Recommendation Report for Planning Permission for Works or Extension to a Dwelling

REF NO: BR/100/19/HH

LOCATION: 26 Kew Gardens
Bognor Regis
PO21 5RD

PROPOSAL: Single storey side and rear extension to provide garage and dining room, loft conversion to provide bedroom and shower room

CLIENT
MR AND MRS COURCIER
PROJECT
PROPOSED ALTERATIONS SINGLE STOREY AND LOFT EXTENSIONS 26 KEW GARDENS PO21 5RD
DRAWING TITLE
PROPOSED GROUND FLOOR PLAN
SCALE
1/50 at A3
REFERENCE
11806.07

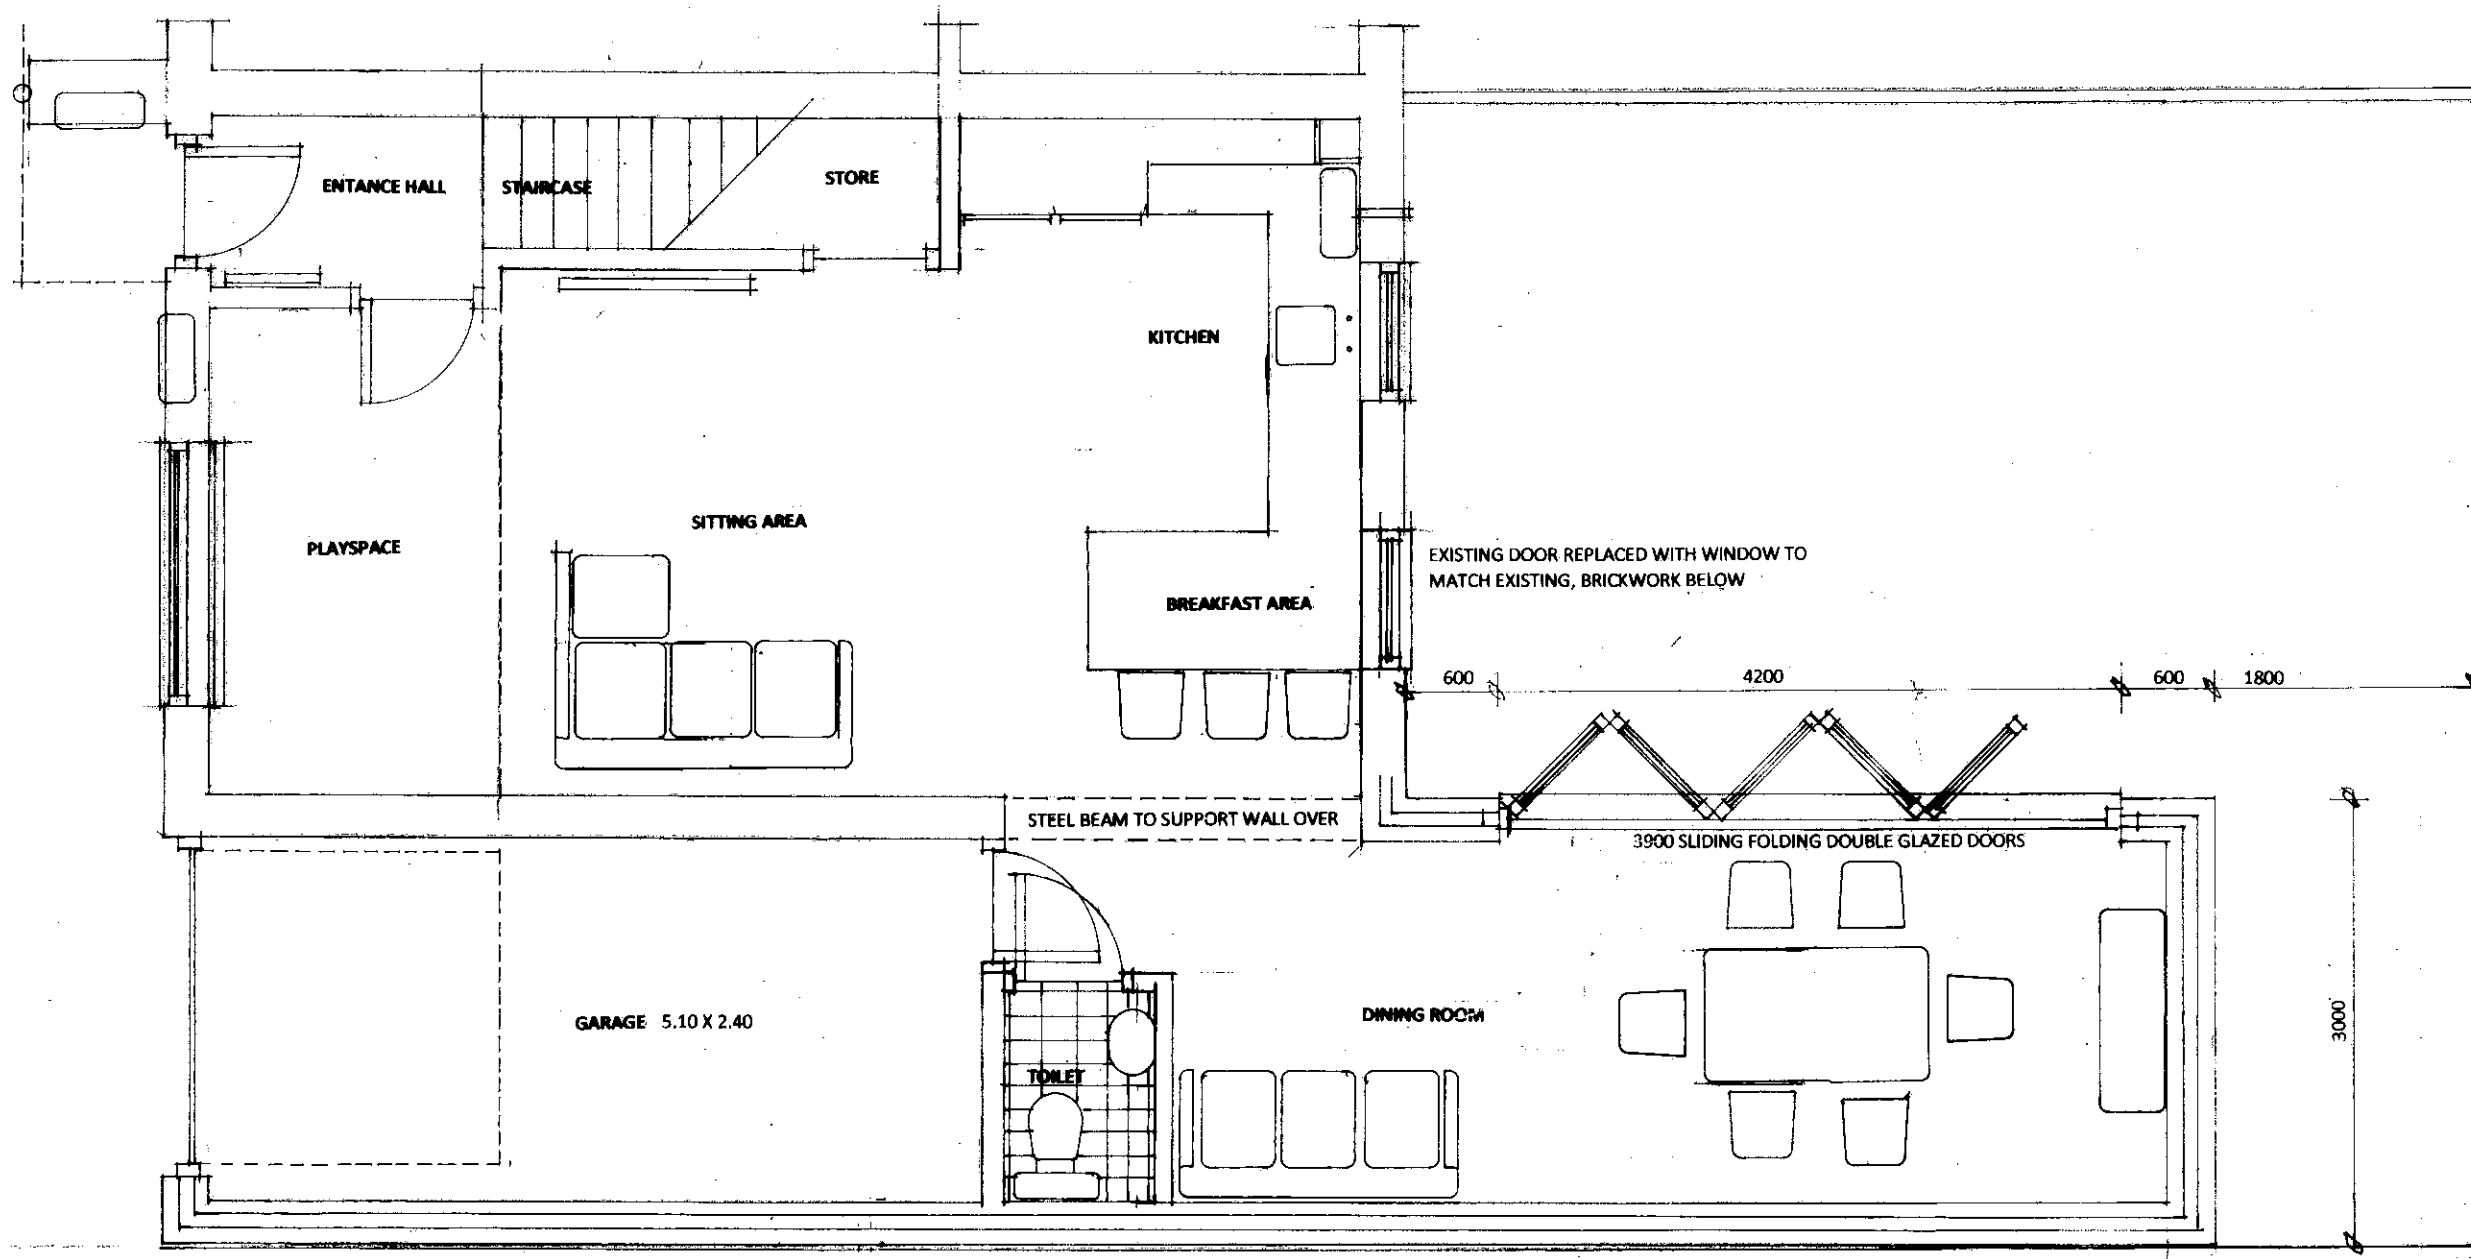
The side extension will be constructed to a height of 2.75m with a flat roof and have a width of 3m. This will run 13.4m along the southern boundary and extend 5m beyond the rear of the dwelling.

2 doors will be replaced with windows to the rear elevation of the dwelling with the only additional doors on the proposal being situated to the northern elevation which will provide views over the garden of the host dwelling.

CLIENT
MR AND MRS COURCIER
PROJECT
PROPOSED ALTERATIONS SINGLE STOREY AND LOFT EXTENSIONS 26 KEW GARDENS PO21 5RD
DRAWING TITLE
PROPOSED CROSS SECTION
SCALE
1/50 at A3
REFERENCE
11806.13

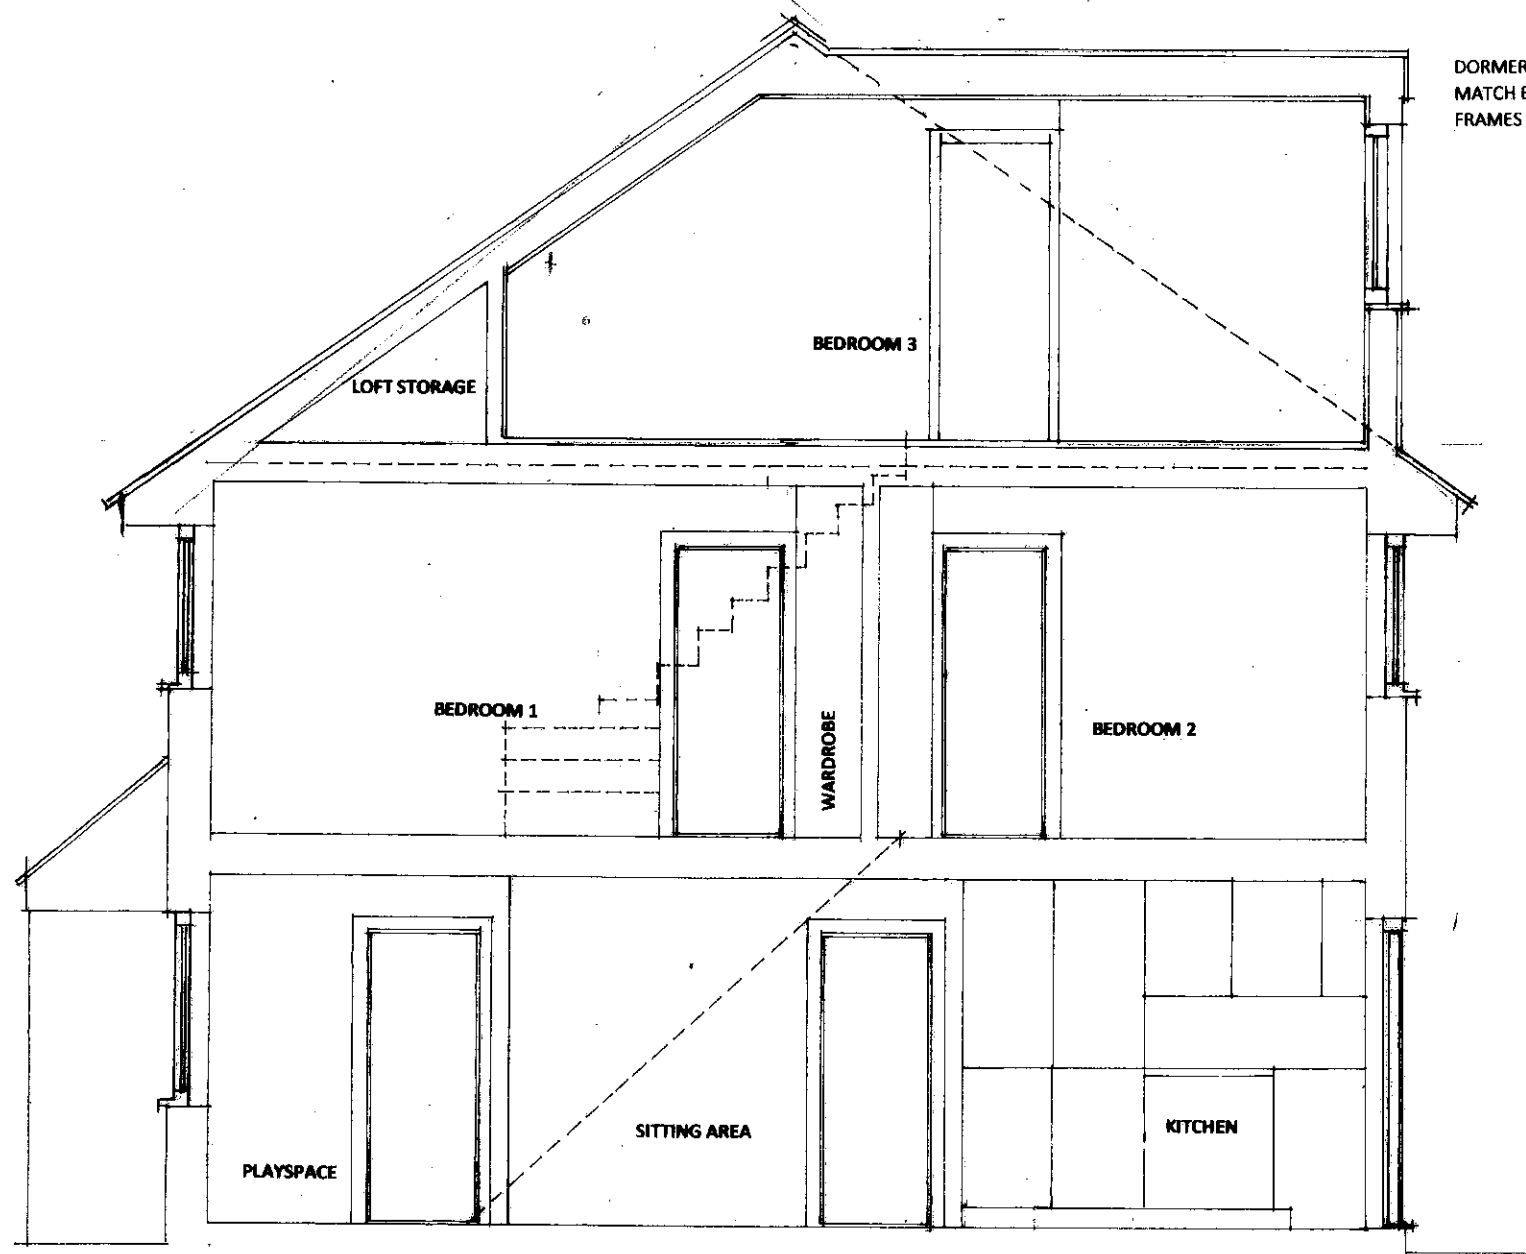
A dormer will also be constructed to the rear elevation. The proposed rear dormer extends 3.6m from the existing roof and is proposed to be built to a height of 2.5m. There are no properties to the rear and whilst it may provide views over the neighbouring gardens any overlooking achieved is not deemed significant. It is also noted that the construction of a dormer to this size and location would fall under permitted development.

PROPOSED
ELEVATIONS

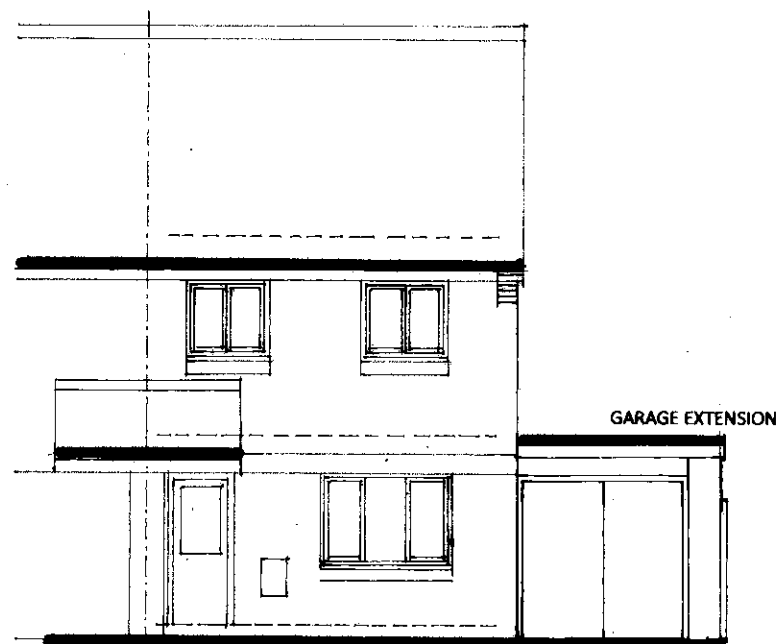
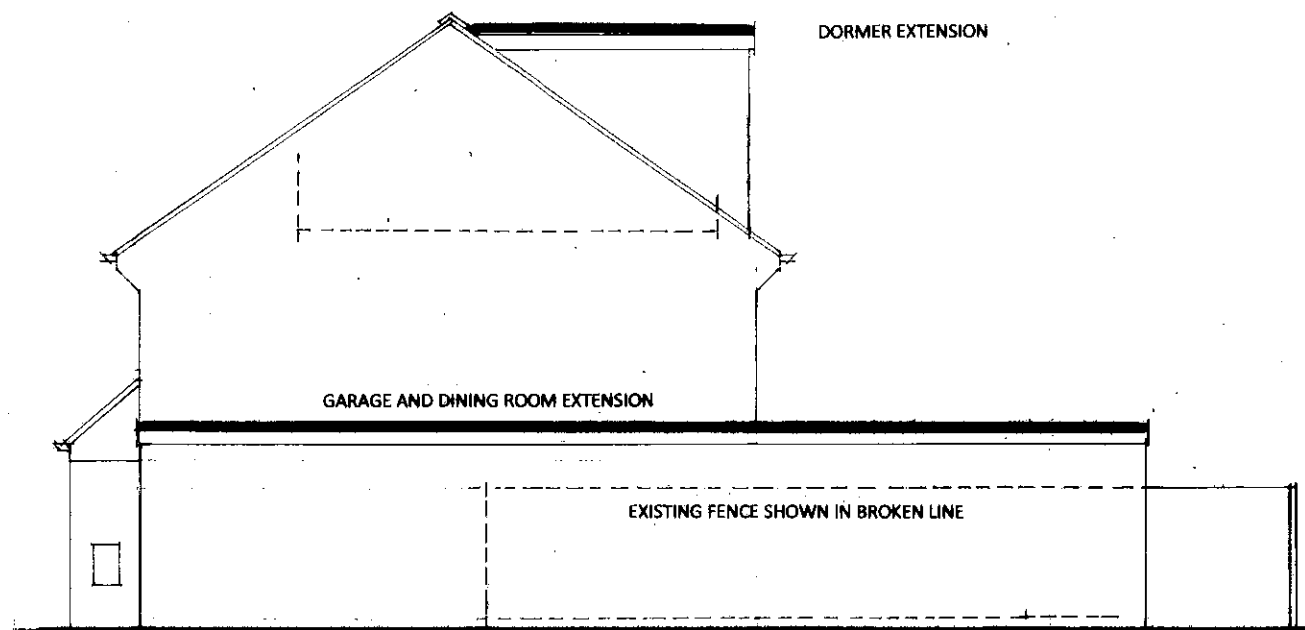
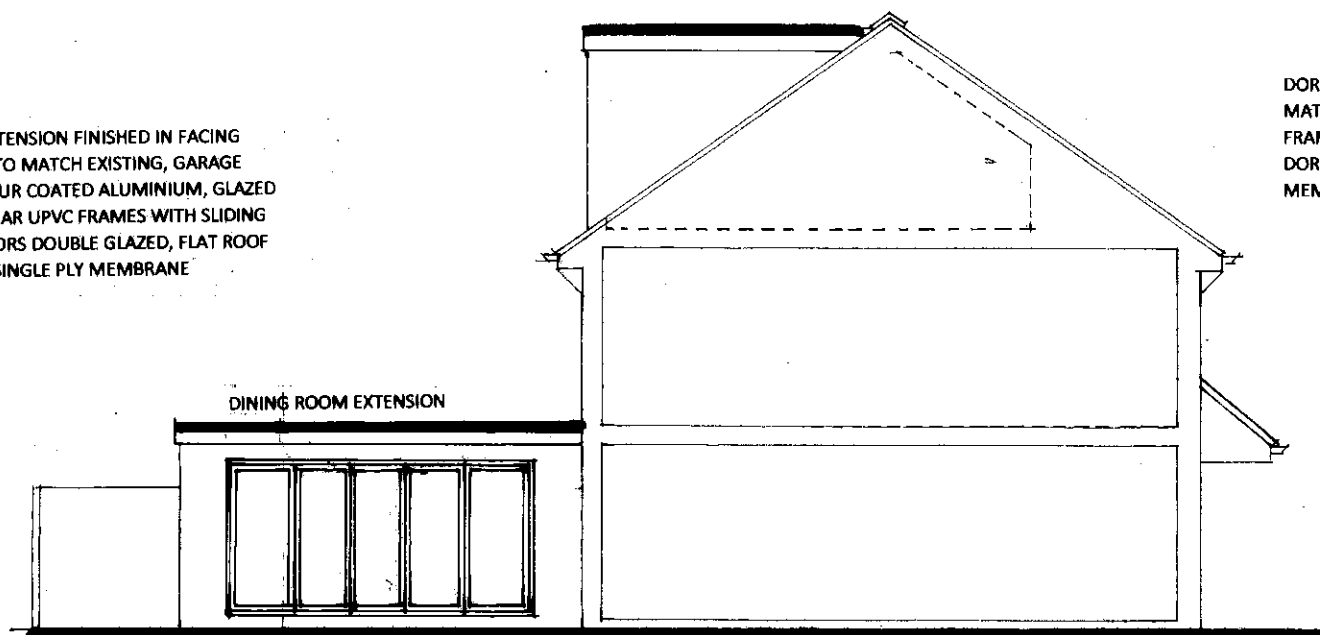
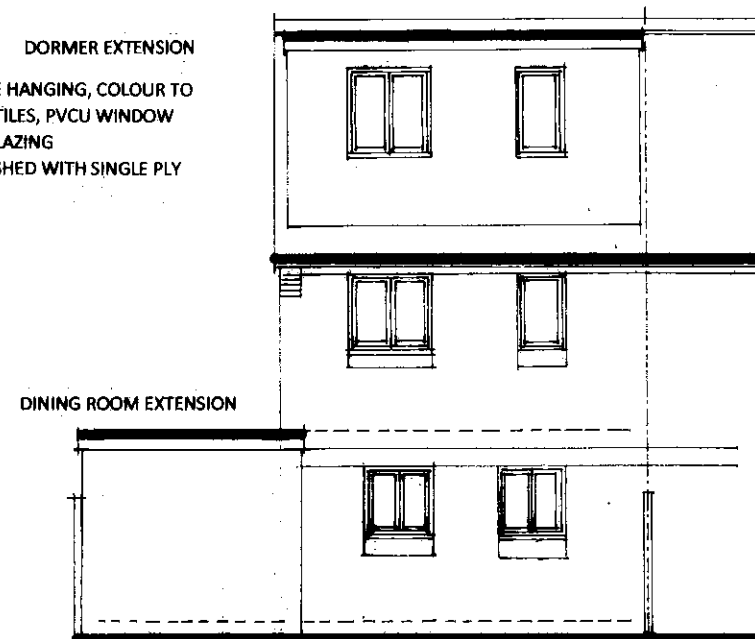
The side extension does not extend beyond the principal elevation of the host dwelling and therefore it is not unduly dominant upon the street scene.

The materials will match the existing property which helps to ensure it appears well integrated. The proposal is not deemed to adversely impact upon the spatial pattern or character of the area and accord with DDM1 and DDM4 of the Arun Local Plan.

Whilst this extends at quite a depth due to its modest height and siting in such that it runs along side the neighbouring driveway the development is not considered to appear significantly overbearing or overshadowing.

The extension when viewed from the neighbouring property at No.24 will intersect a 45 degree angle which is the tool used to assess any serious effects on neighbouring properties daylight, sunlight and overbearing impacts caused. However due to its siting in such that there is a sufficient distance from the neighbouring property any impacts are not considered significant in which a refusal is justified.
